DOC24/388894
24 June 2024

EPA Advice on Environmental Impact Statement

Thank you for the request for advice from Public Authority Consultation (PAE-70891485), requesting the review by the NSW Environment Protection Authority (EPA) of the Environmental Impact Statement (EIS) for the proposed Copi Mineral Sands Project (Application SSD-41294067) located approximately 75km northwest of Wentworth and 180km southwest of Broken Hill, within the Wentworth Local Government Area (LGA).

Figure C1 Estimated areas of wind erosion sources (Scenario 1)

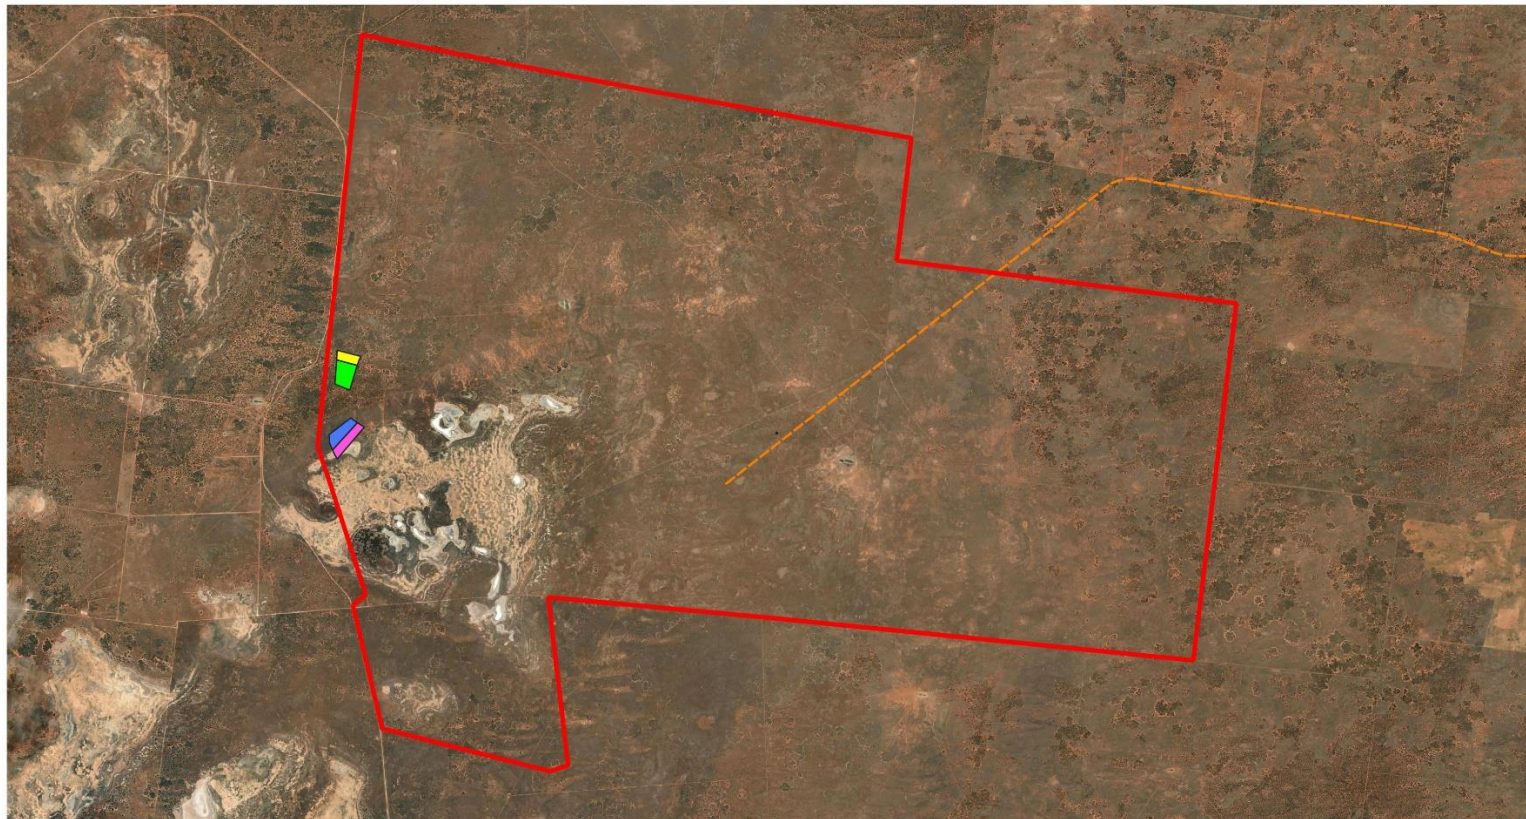
2. Emissions inventory lacks detail regarding wind erosion of exposed areas

The emissions inventory within the AQIA outlines several exposed areas susceptible to wind erosion including vegetation cleared, overburden removal area, overburden backfill area, soil spreading and revegetation. These areas were identified to have a combined area of 5.3ha for annual emissions in scenario 1. However, the AQIA states that the active area of exposed areas (except for the HMC storage area), is taken to be 10% of the total area. It is understood that the limit of disturbance equates to approximately 5622ha, therefore 10% of this figure is significantly greater than the provided value of 5.3ha. The EPA notes that the AQIA is unclear regarding how these areas have been calculated since the emissions inventory does not provide adequate detail.

The emissions inventory includes “soil spreading and reveg area” however, it is unclear if the figures attached to this description match the intended scale of revegetation/rehabilitation of the project. Rehabilitation is proposed to occur progressively throughout the life of the project, with the extraction area progressively backfilled, shaped and rehabilitated. The Emission Estimation Technique Manual for Mining¹ recommends emission reduction factors between 30% - 90% depending on the level of rehabilitation, whilst an emission reduction factor of 100% is reserved for fully rehabilitated areas. Rehabilitation is expected to cover a significant portion of the limit of disturbance over the project duration. The EPA notes that the scale of rehabilitation does not appear to be reflected within the emissions inventory. Wind erosion of exposed areas has the potential to form a significant portion of the project related dust emissions, therefore the assessment should reflect the scale of such areas and outline proposed controls where appropriate.

Recommendation: *The AQIA be revised to enable emission estimates to be assessed and replicated for exposed areas susceptible to wind erosion. Further specific detail should be provided regarding the calculation of all exposed areas (including rehabilitated/revegetated areas and the off-path storage facility) to ensure the emissions inventory is accurate, transparent, and able to be replicated. The updated AQIA should include consideration regarding the anticipated level of rehabilitation achieved for each scenario.*
